Consultation Response from KC, Conservation and Design
2020/90609 Tolson Cottage, Dean Brook Road, Armitage Bridge, Huddersfield, HD4 7PB
Erection of detached car port and store (Listed Building within a Conservation Area)
Date Responded: 8.4.20
Responding Officer: Sue Oakley
Responding Ref:

Project	
Proposed Car Port.	
For	
Mr & Mrs G Shaw.	
Address	
Tolson Cottage Dean Brook Road Armitage bridge HD4 7PB	
Title	
Planning Drawing.	
Drawing number	Date
01 C.	Feb 2020.

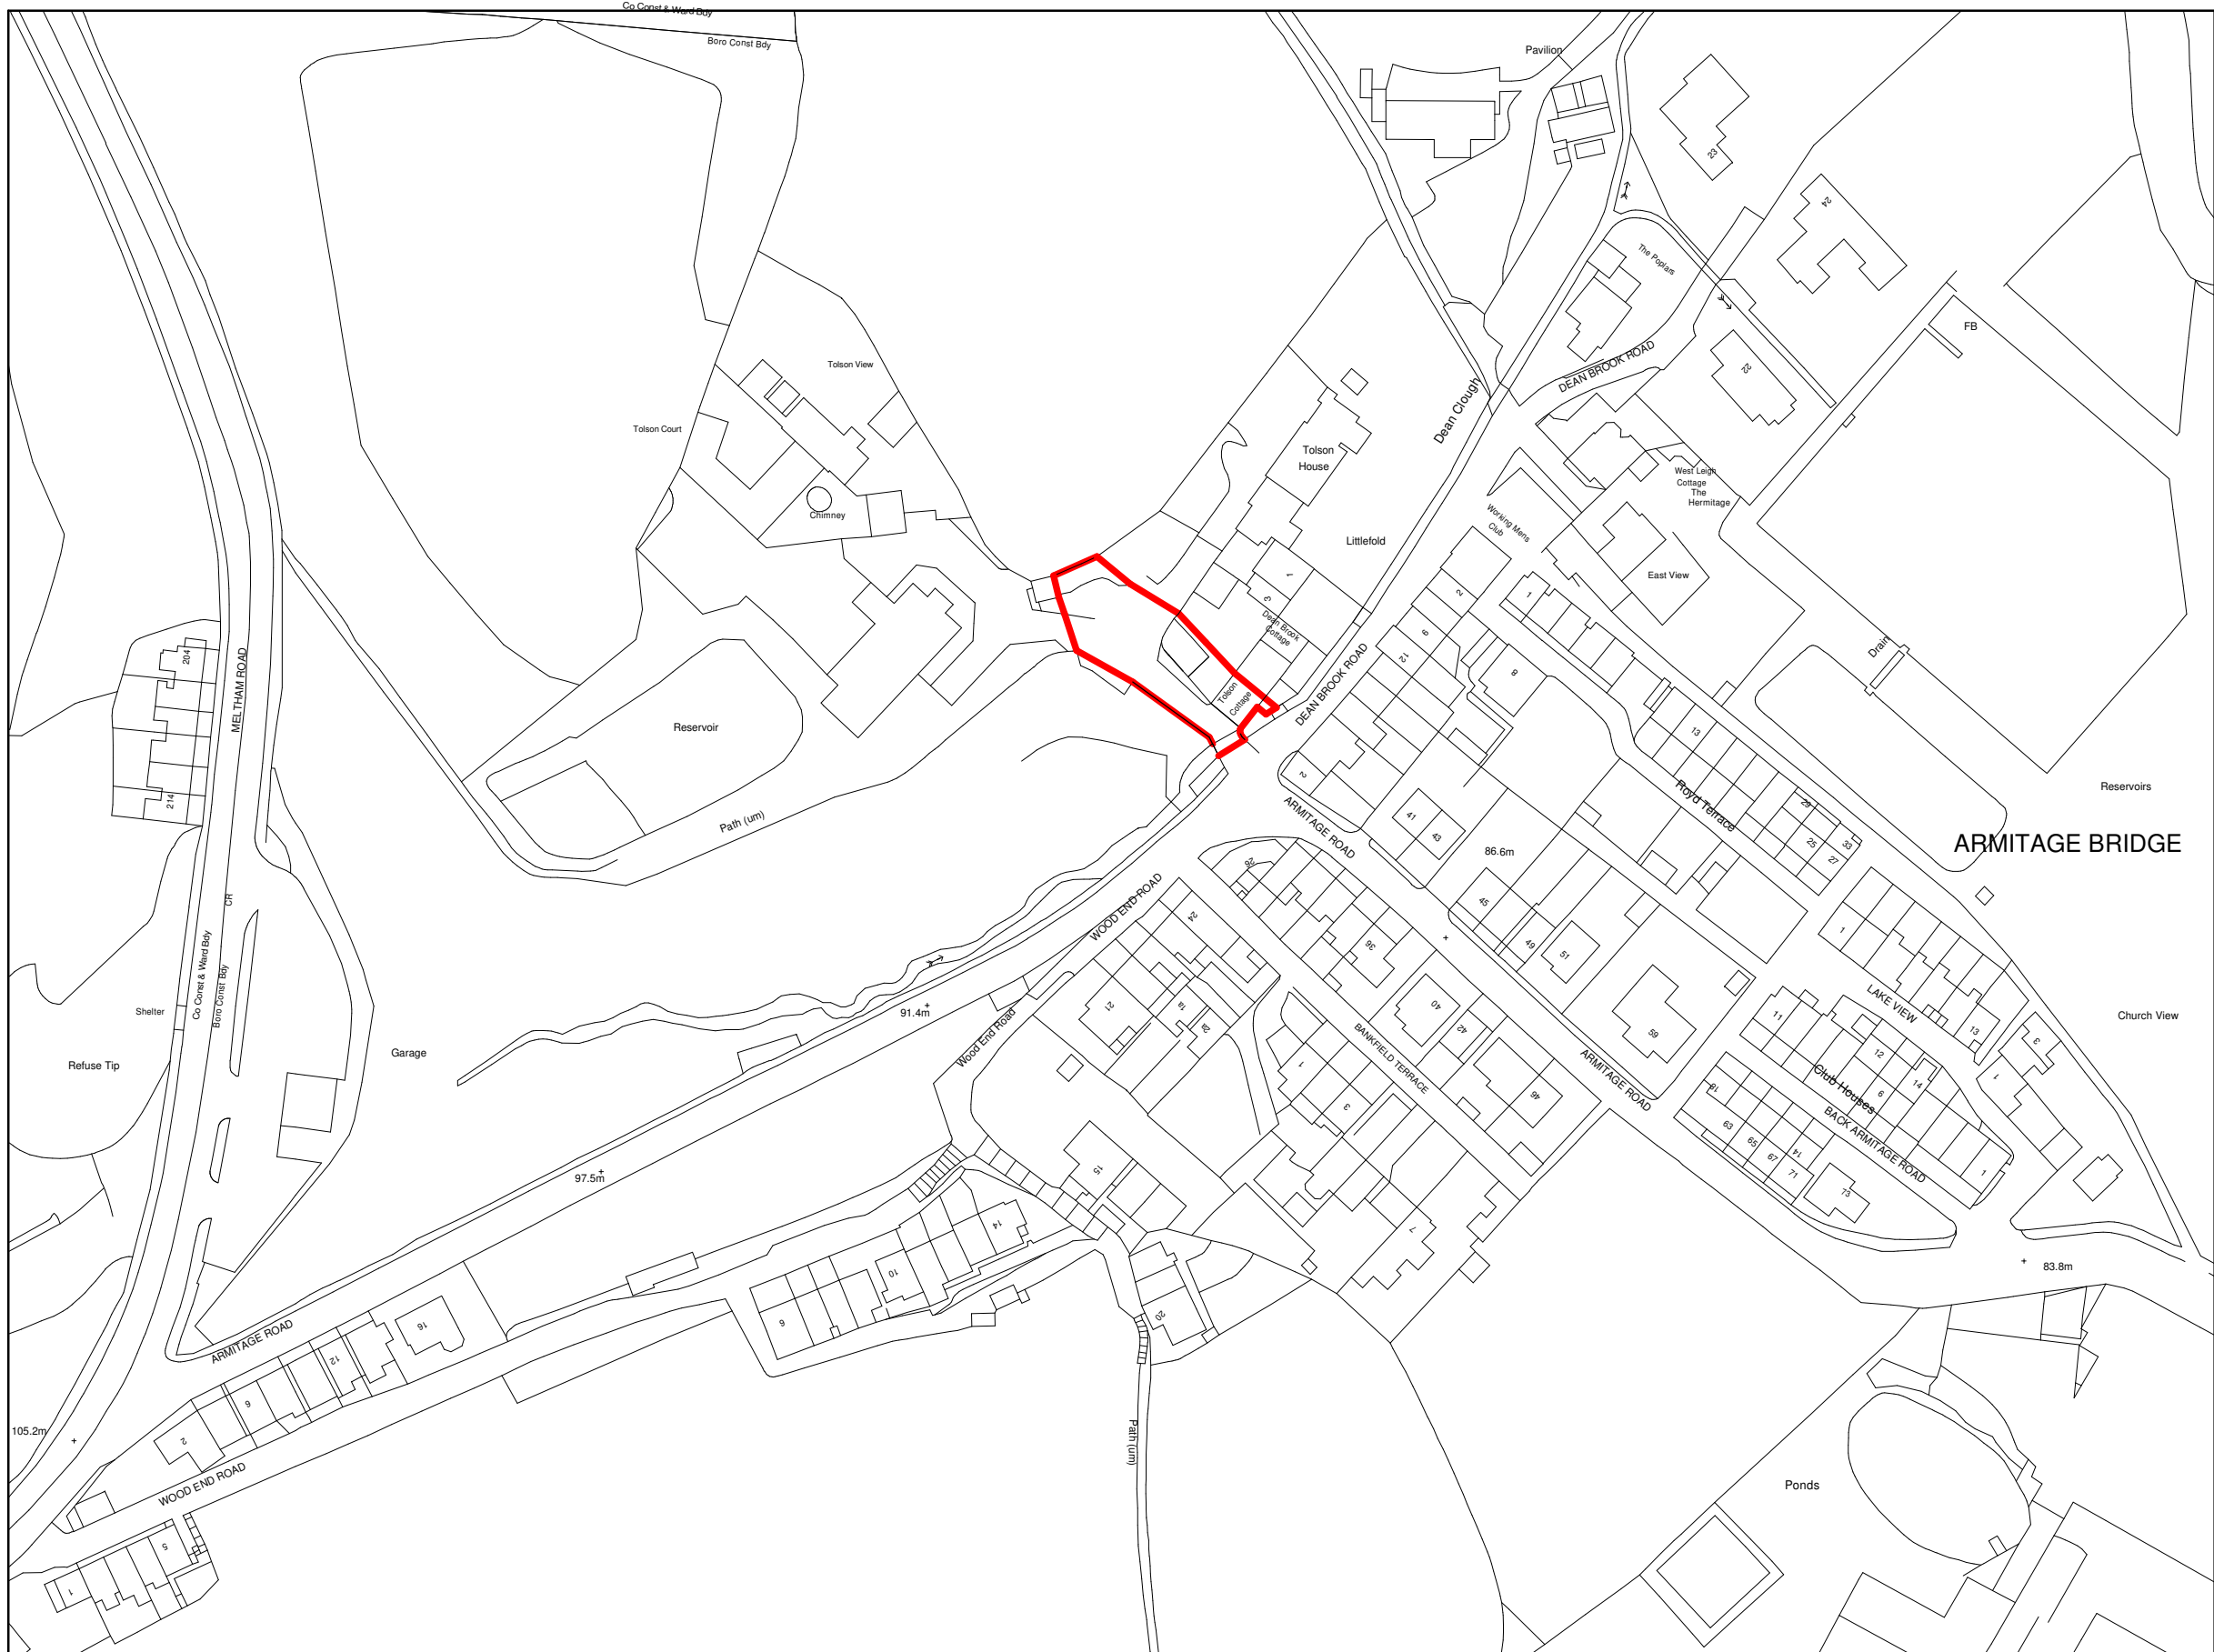
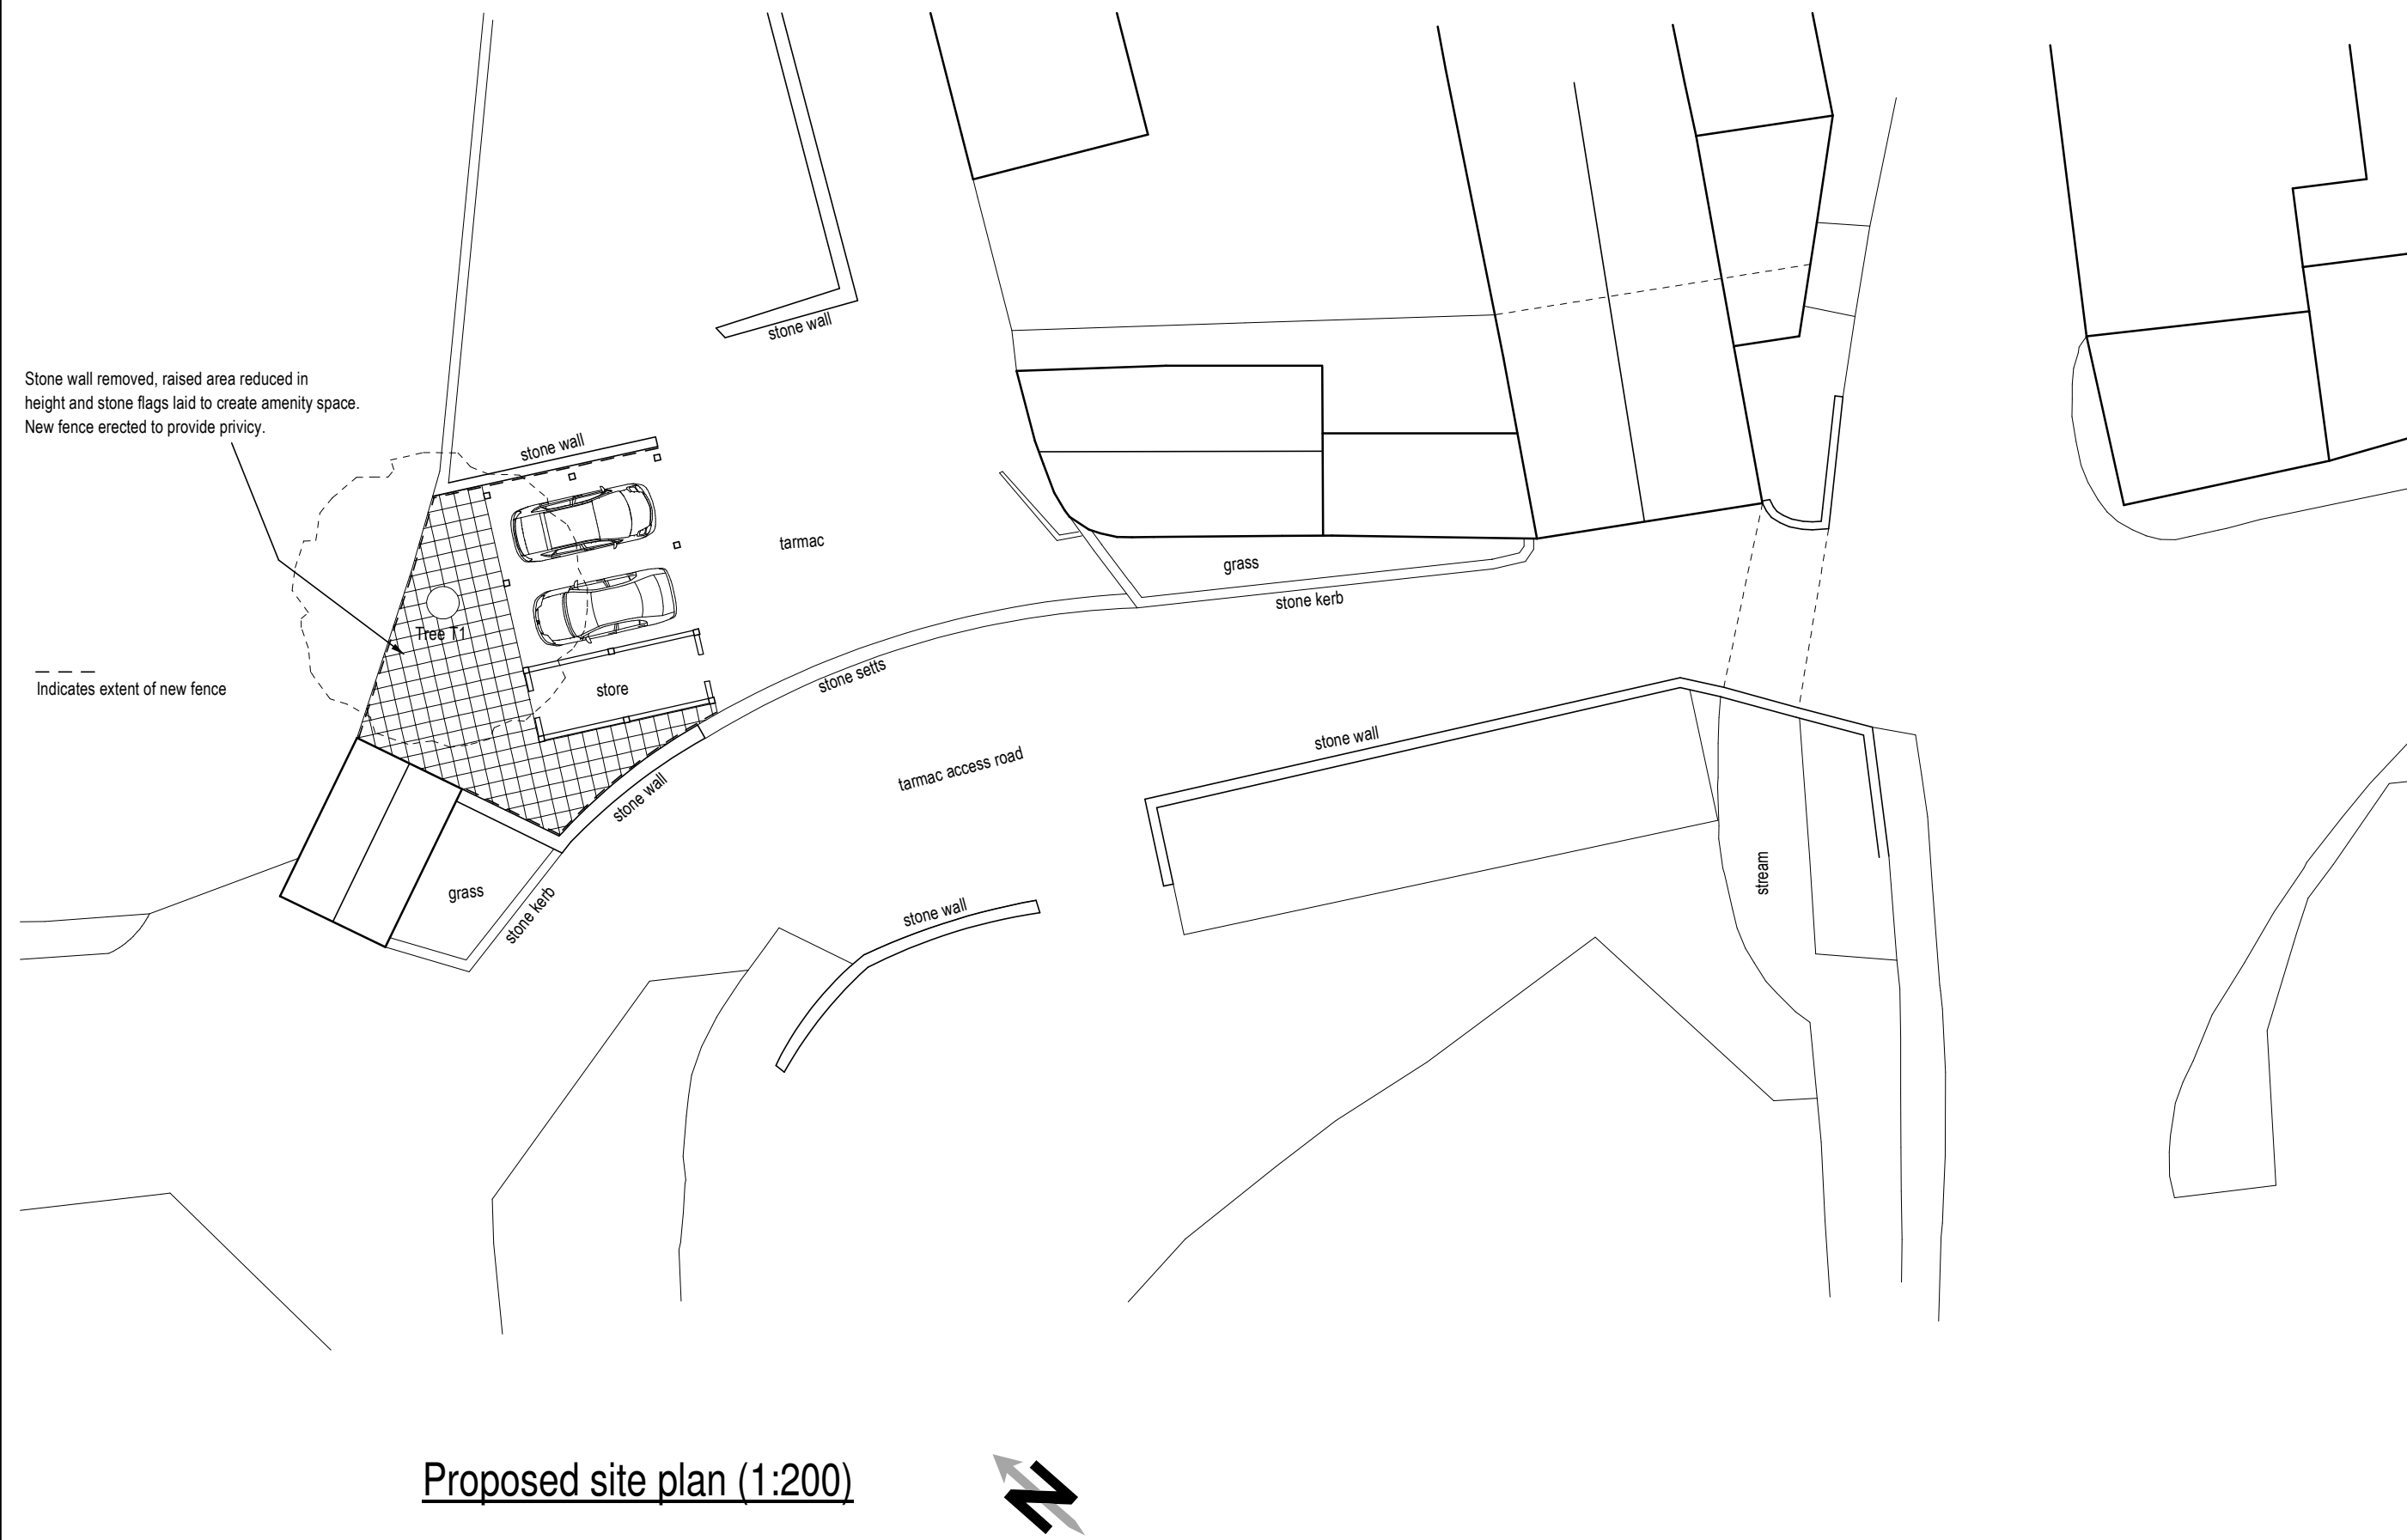
The drawing shows a new fence around the car port, but its height is not provided. The conservation area is characterised by stone walling and a lightweight wire fence around the adjacent field. The construction of a domestic close boarded timber fence will harm the character of this part of the conservation area and should be omitted from the proposal.

I would consider this proposal to cause slight harm to the character and significance of the conservation area and I have concerns about the recent garage conversion being used to justify the proposal as this is a private, not public, benefit. Although the framework of the car port is open, the structure has a pitched slate roof and a solid stone store to one side, which would add to the loss of views and open space within this conservation area.

If this proposal is considered acceptable in principle, I would prefer it to be redesigned to reduce the mass.
